Application H16-0209-25
Location THE SESSIONS HOUSE SHEEP MARKET SPALDING PE11 1BB
Proposal Removal of tiered benching viewing gallery in the old courtroom

Address: Sessions House, Sheep Market, Spalding, PE11 1BB
Application Ref: H16-0209-25

Proposal: Removal of tiered benching viewing gallery in the old courtroom.
Statutory Remit: Historic Buildings & Places (formerly the AMS) is a consultee for Listed Building Consent applications, as per the Arrangements for handling heritage applications - notification to Historic England and National Amenity Societies and the Secretary of State (England) Direction 2021. We are concerned with historic assets of all types and all ages, including conservation areas and undesignated heritage.

PROJECT TITLE Proposed Removal of Tiered Viewing Gallery	CLIENT Castle Events Ltd, The Sessions House, Sheep Market, Spalding	CHK BY ---	DRAWN BY CLA
DRAWING STAGE Planning	SCALE 1:50 @ A1	STAGE PLN	REV D
SHEET TITLE Removal Plan	PROJECT NUMBER PE11-4138	SHT 002

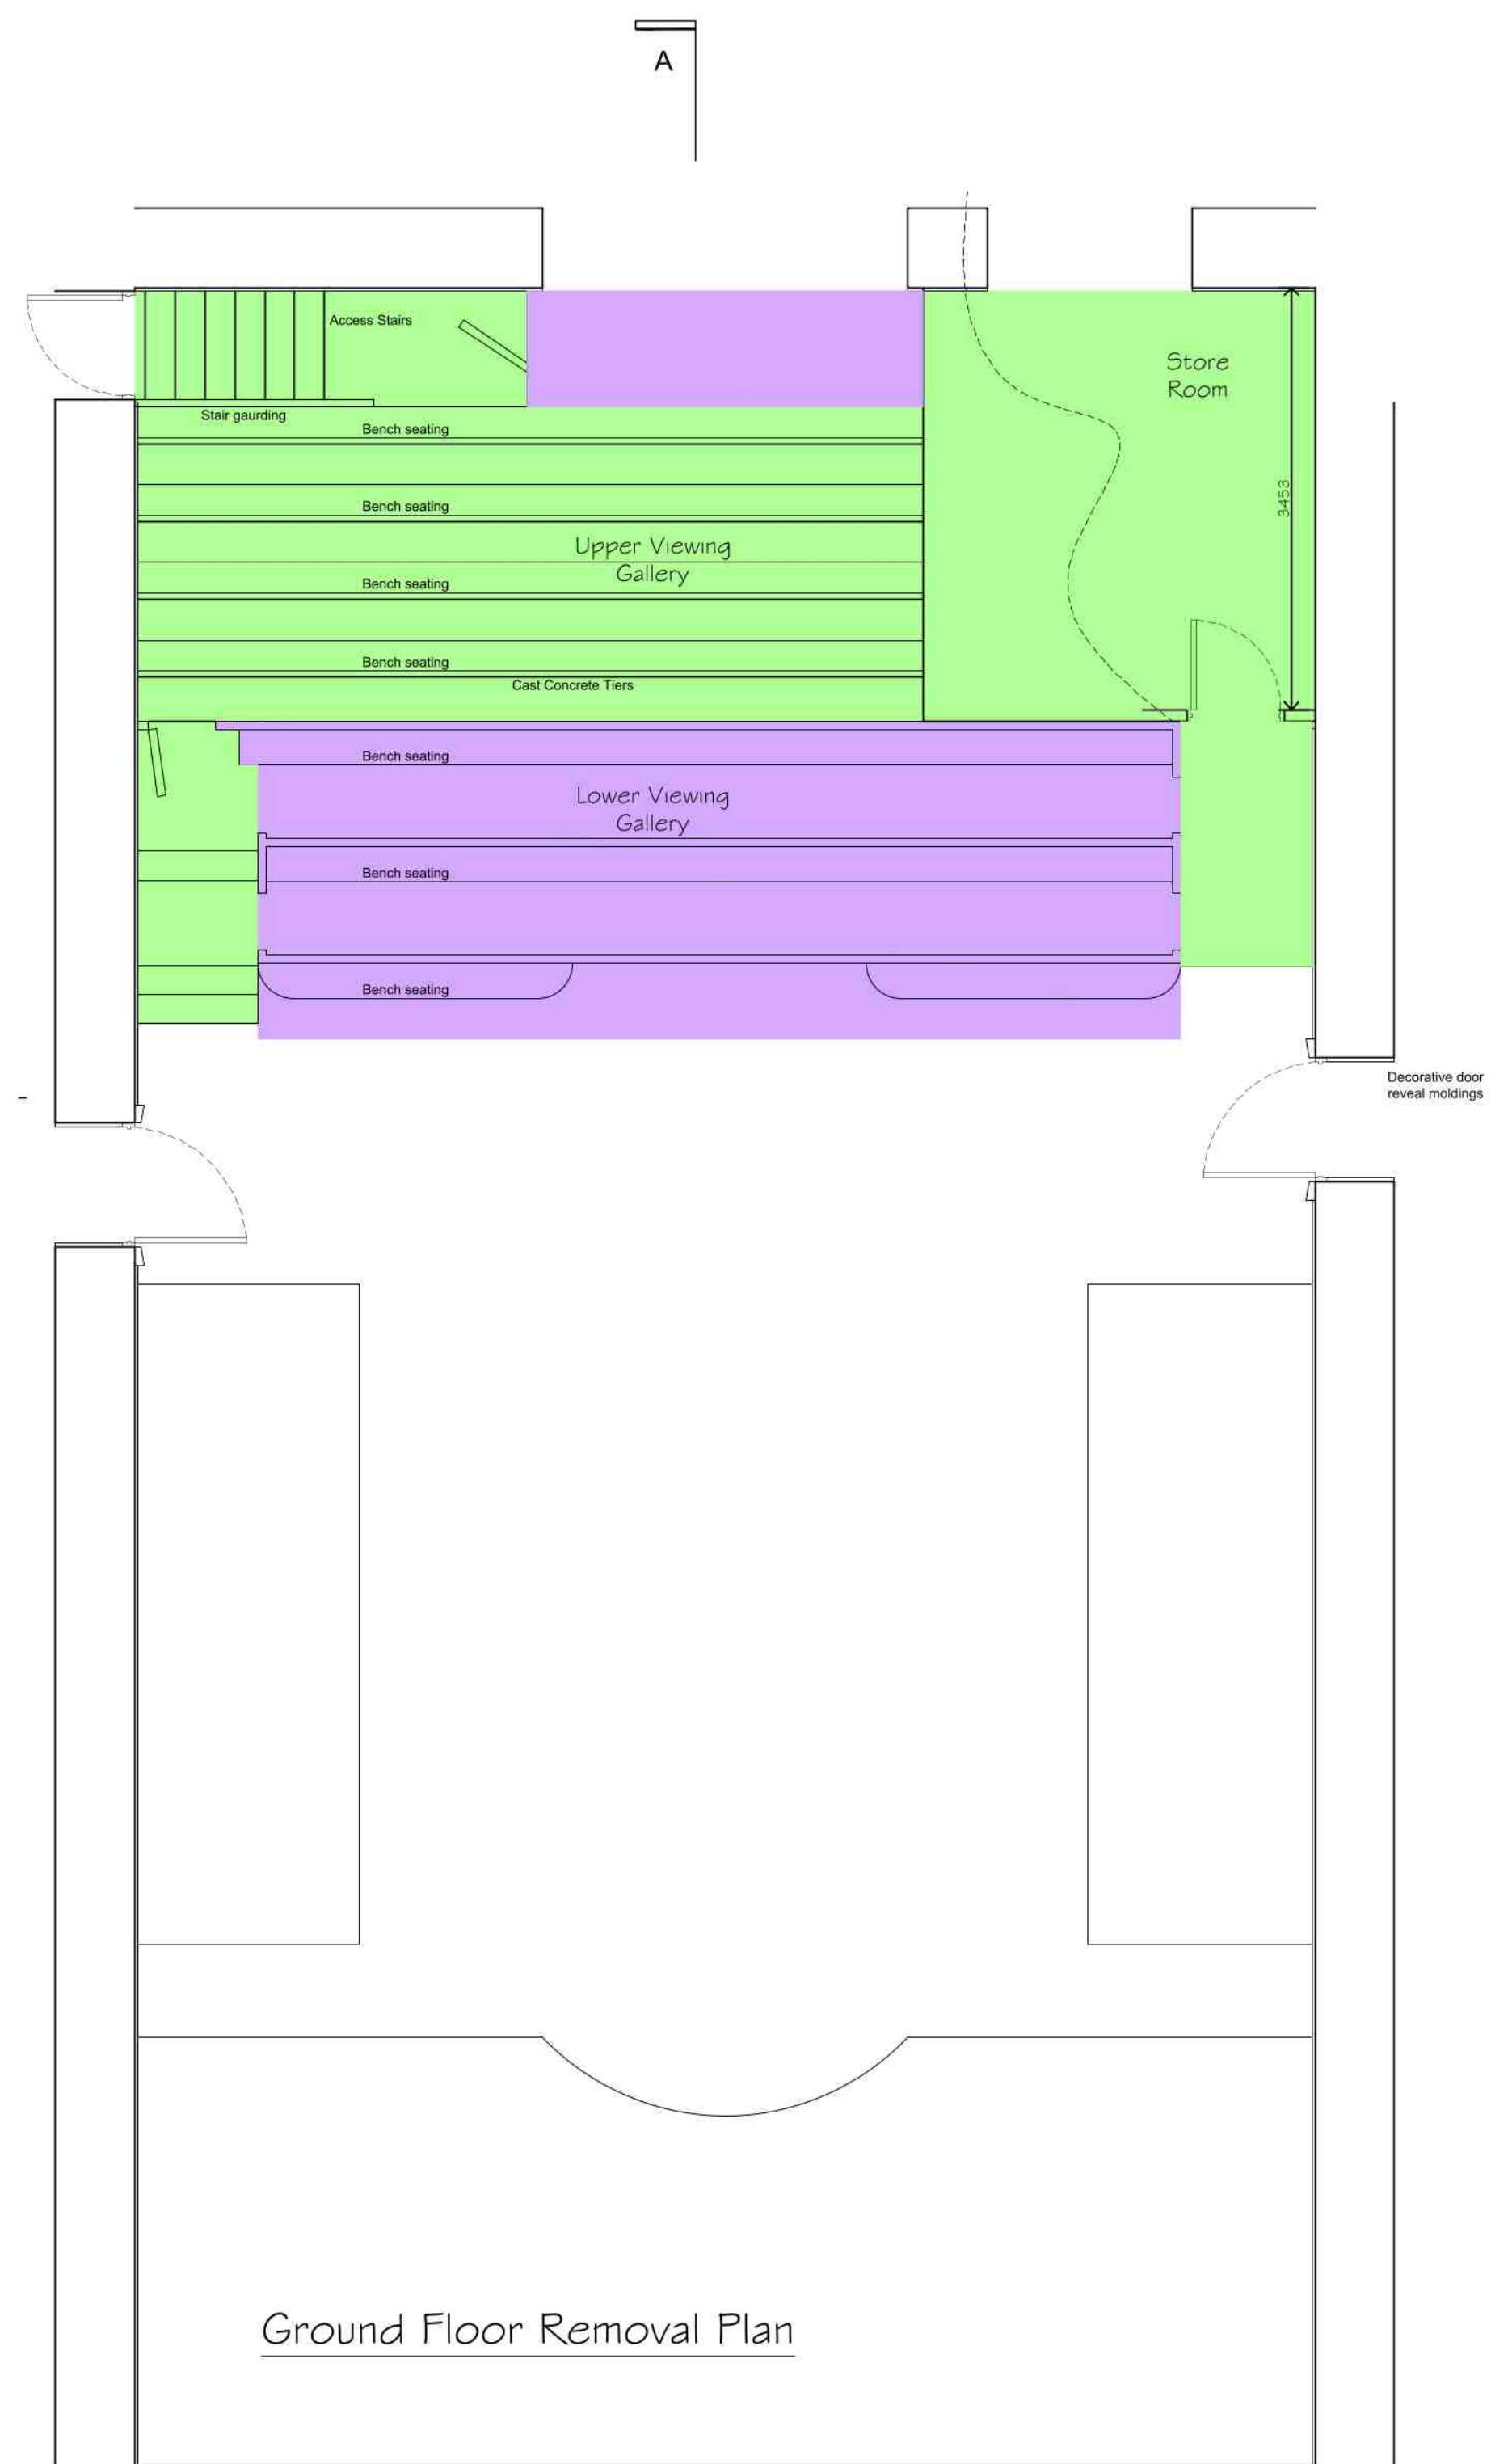
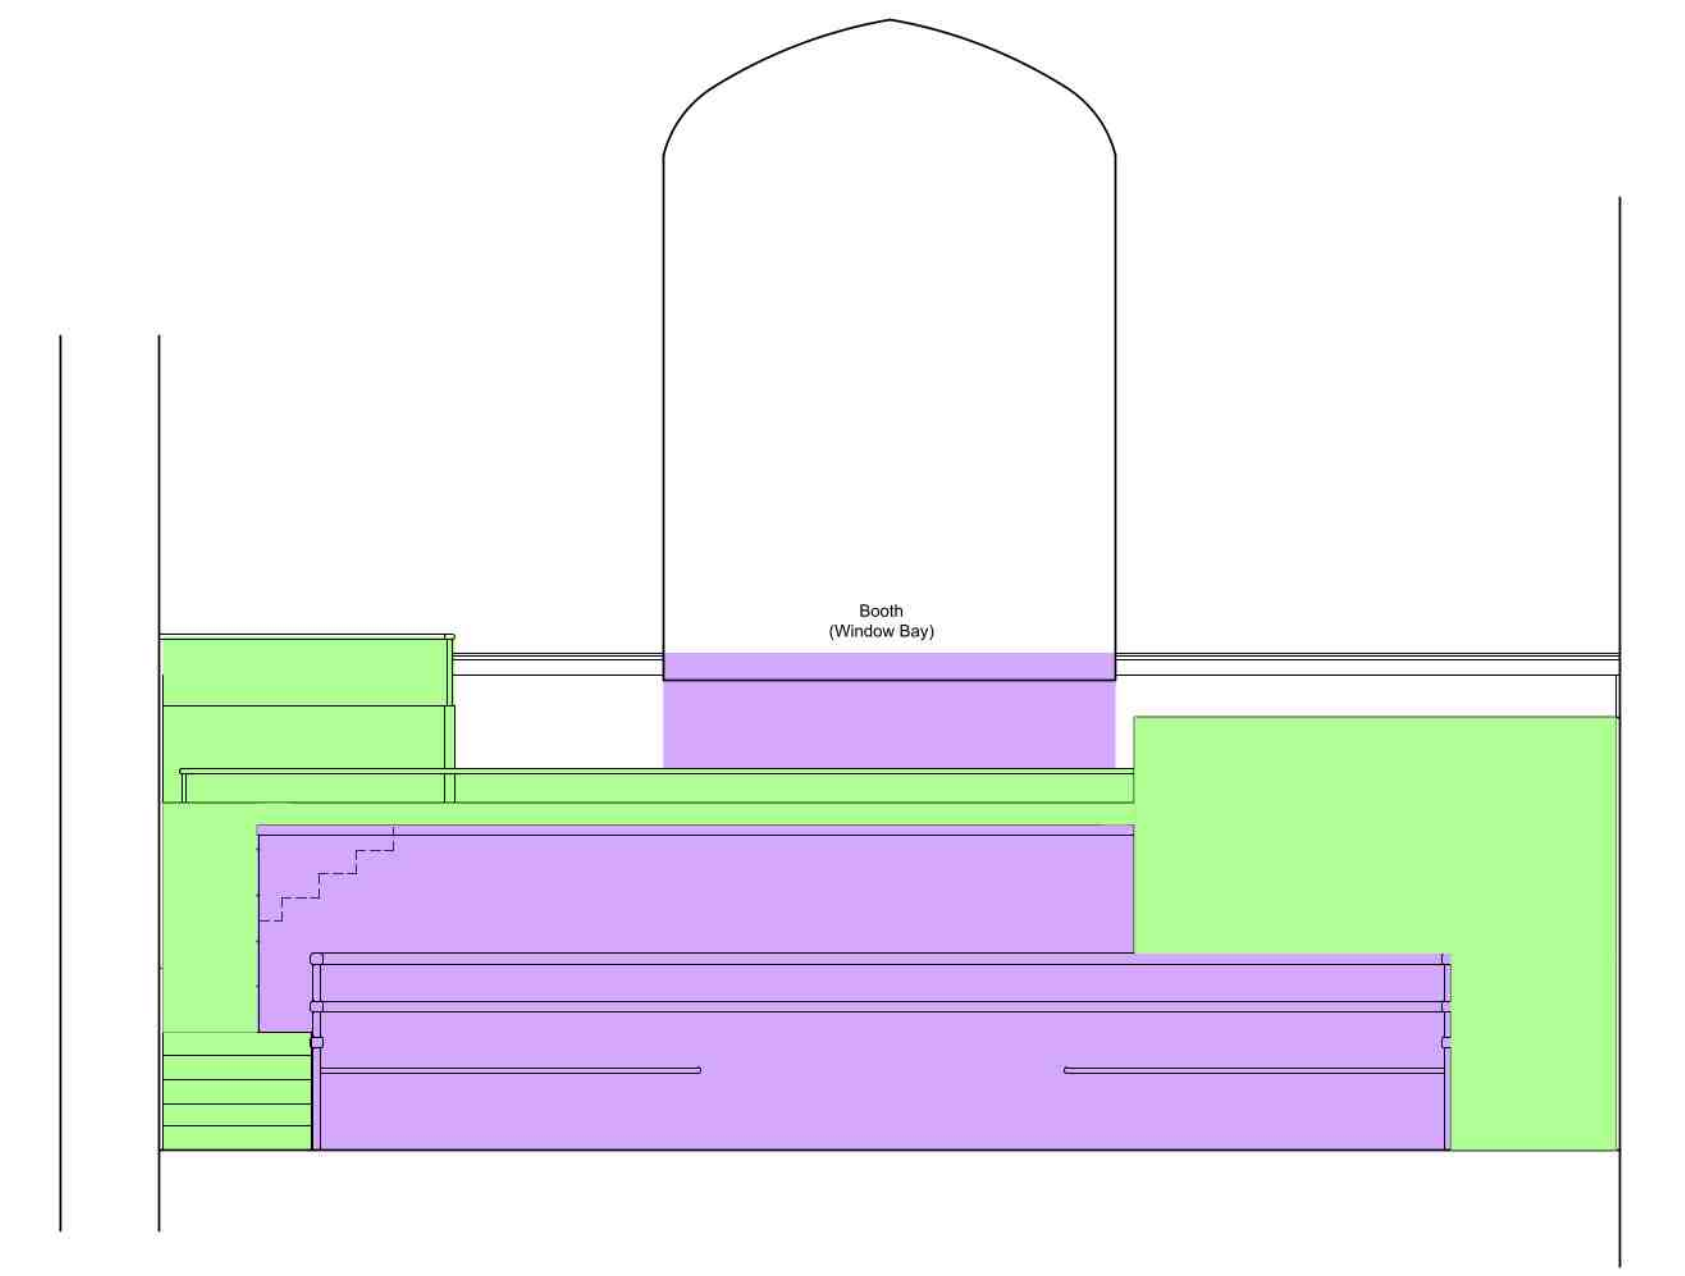
The viewing gallery is part of a 'set piece' of former court furniture and fittings that, as a collection, are important to understanding the history and original use of this heritage asset, and therefore its significance.

However, there also appears to have been alterations in the past and the viewing gallery may not be original. Based on limited images of the building, externally it appears the rear window may have been altered and partially infilled and the window to its side also appears to be a later addition, given it is inconsistent with other windows in the building. The use of cement to create the tiers would also seem uncharacteristic. What is the purpose of the small room to the side? Is this a later addition? We suggest that the heritage statement is revised to properly investigate the original form of the courtroom, any later changes, and determine the age and significance of the fittings.

The above issue aside, the removal would leave the horizontal window to the left side of the main window somewhat jarring with the appearance of the rest of the room, and the side door would be left out of context, isolated up the wall.

HB&P recommend investigating options to retain at least some of the gallery to maintain the sense of enclosure currently provided by the courtroom fittings around each side of the room. Subject to further investigation, the first two tiers appear to align with the height of the rear doorway, and as a compromise, repositioning these tiers to the rear wall may result in a satisfactory outcome that balances heritage and alternative uses of the room.

HB&P therefore recommend submission of an updated heritage statement and an options appraisal and amended plans.
